Application: SSI 7485

I write regarding the proposed modification to M4-M5 Link, Mod 2 The Crescent overpass and changes to pedestrian infrastructure in North Annandale, Rozelle and Rozelle Bay Foreshore area.

Figure 4-2 Pedestrian and cyclist bridge infrastructure options

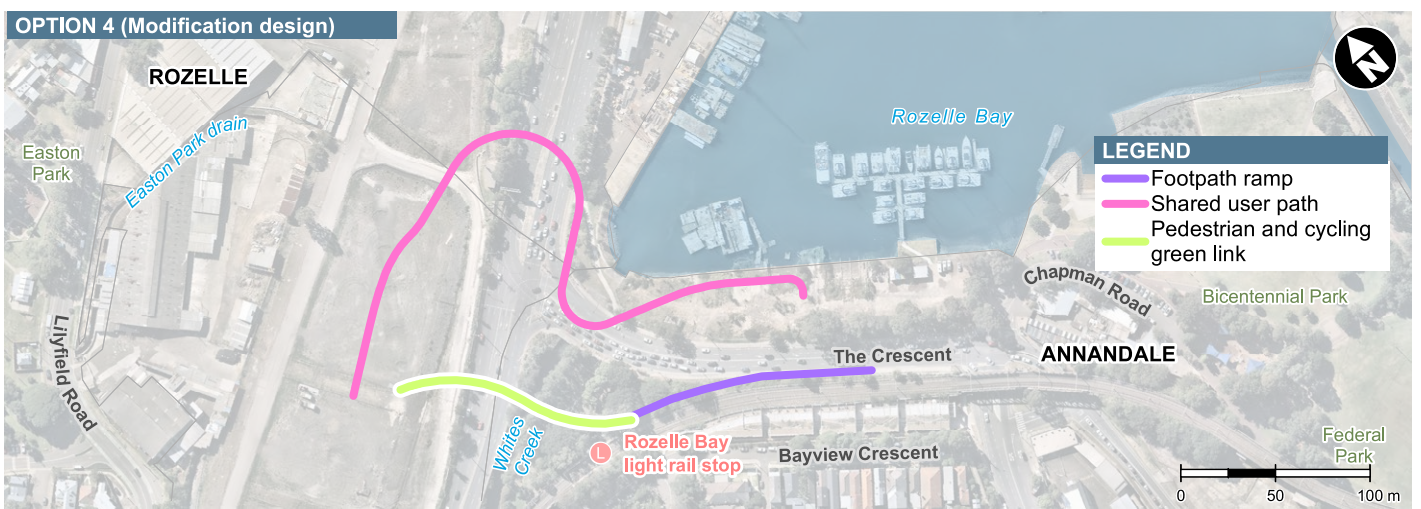
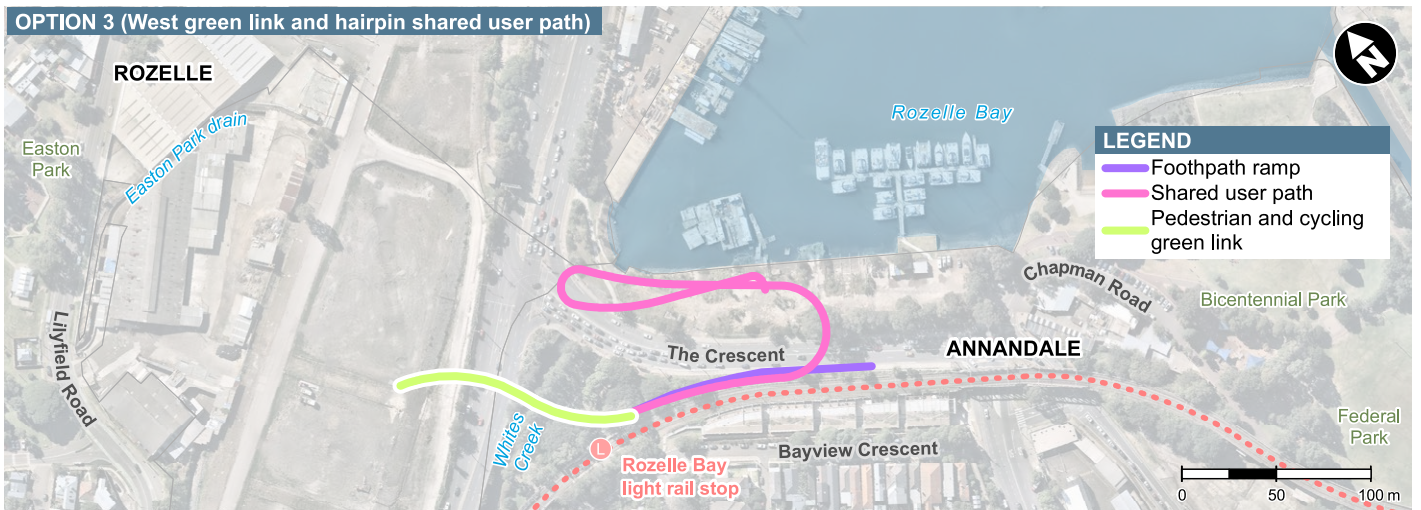
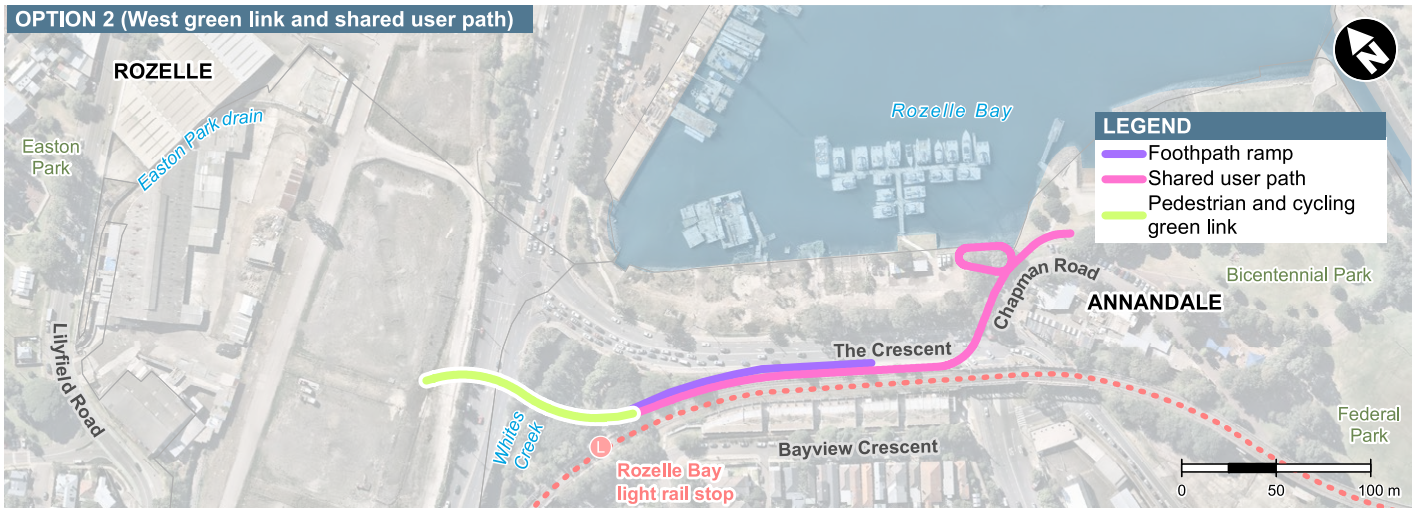
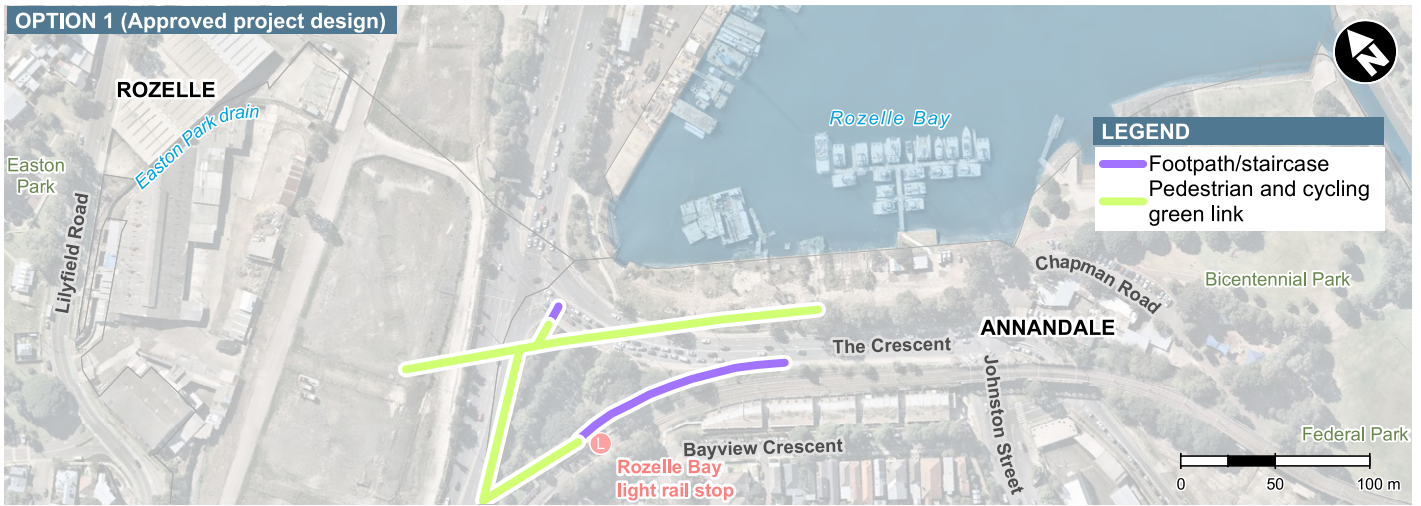
I request RMS work with the community to explore alternate design options to the proposed new car overpass design and the changed pedestrian and cyclist links. I am seeking the reinstatement of the safe, direct access from the approved EIS GreenLink to create a continuous green open space connection from the Rozelle Rail yards and Annandale to the foreshore. The GreenLink was more than just a walk way - it put people central to the design, maximising safety, and providing much needed accessible open space for the community now and into the future Bays Precinct design.

- Reinstate the GreenLink connecting communities and green open space from Rozelle to Bicentennial Park
- Relocate and design pedestrian and cyclist connections that are continuous, safe and direct.
- Design the modification infrastructure and active links in response to the character of the suburbs, the location of the foreshore and it's potential future development.
- Provide pedestrian and cyclist paths that maximise people safety and do not force them onto busier streets, unsafe concrete plazas and caged walkways.
- Integrate active and direct connections to all active transport – including the future Metro West and Foreshore Ferry Wharf

Figure 4-4 Elevation: Indicative view of The Crescent overpass

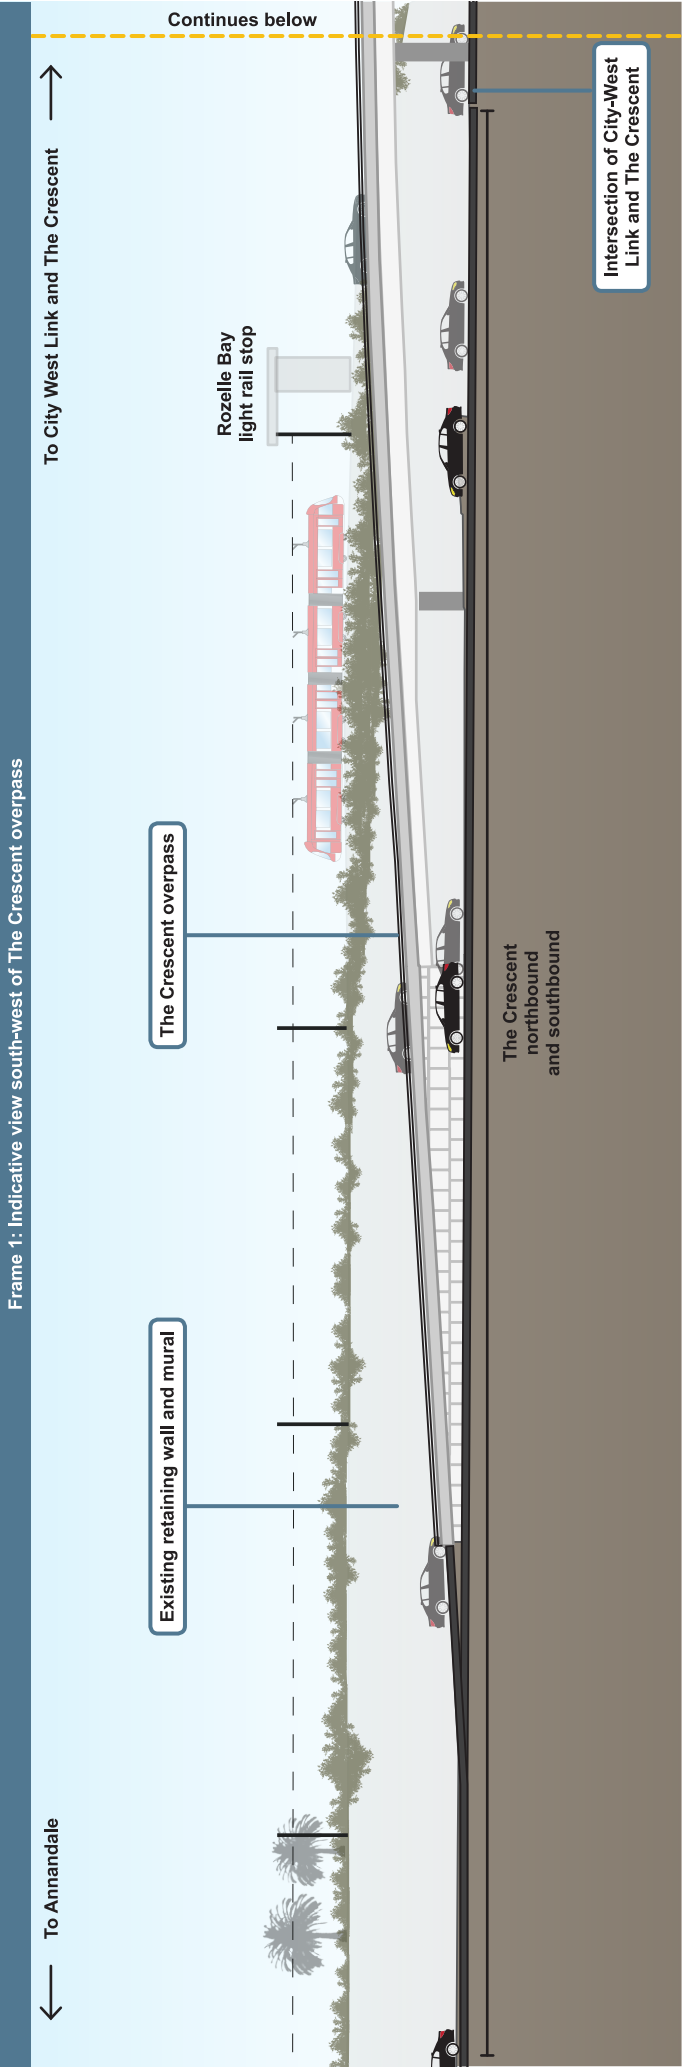
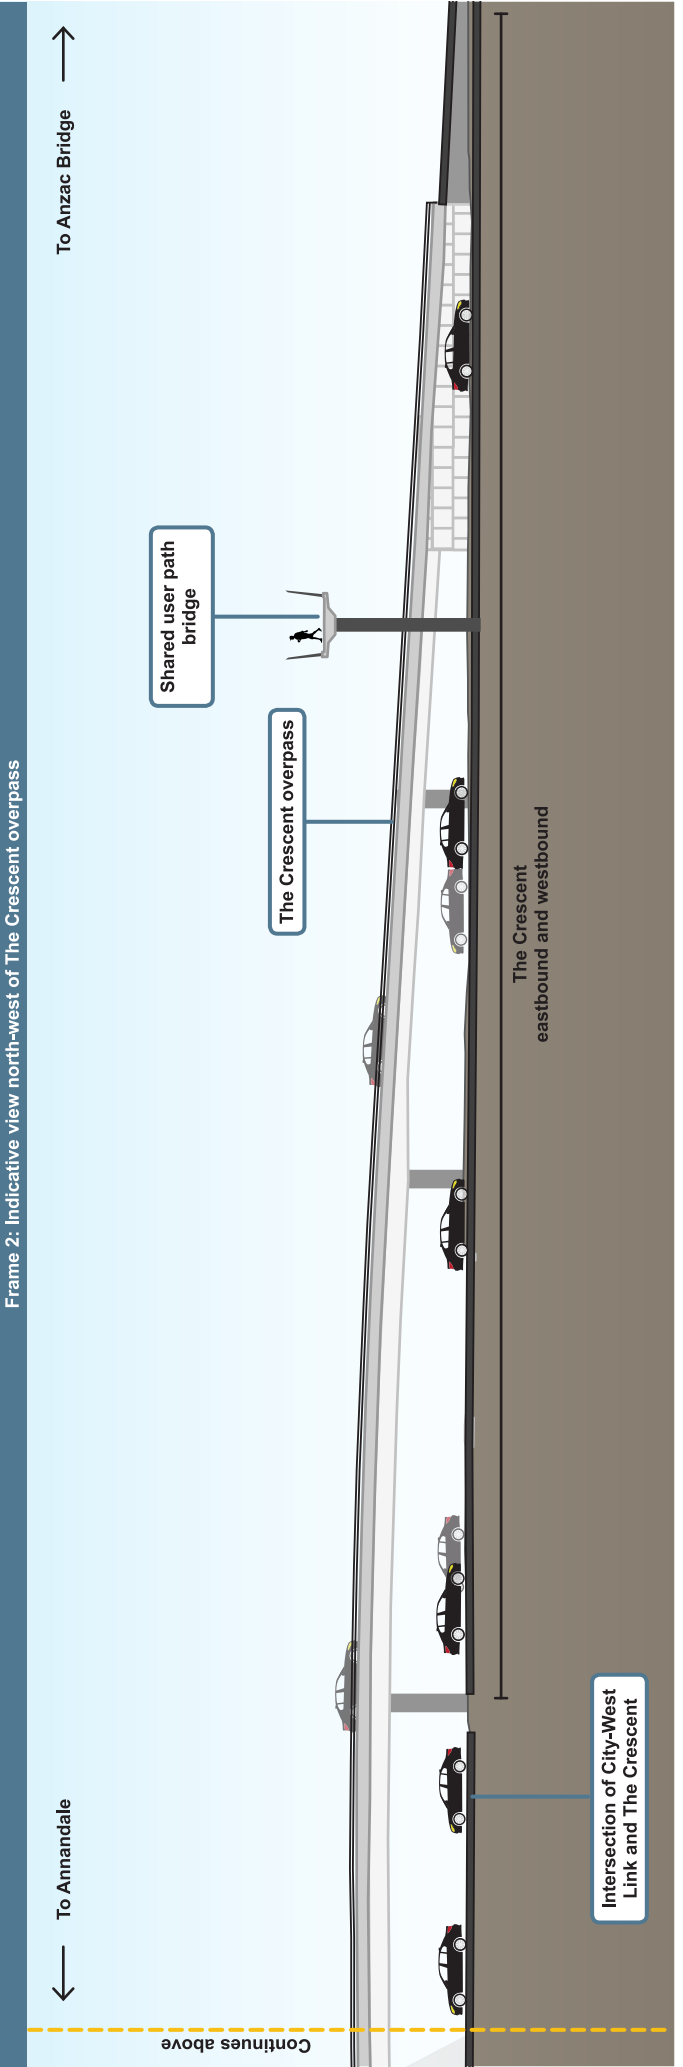
The Glebe Foreshore is a valued area of green space in an inner city suburb. The proposed car overpass will detract from this, akin to the Cahill Expressway at Circular Quay. ~~Other~~ If the plan which has actually been approved - and includes a much desired GreenLink - is not adequate, this overpass is not an inspired solution. Let's instead work towards a solution that people will appreciate into the future.
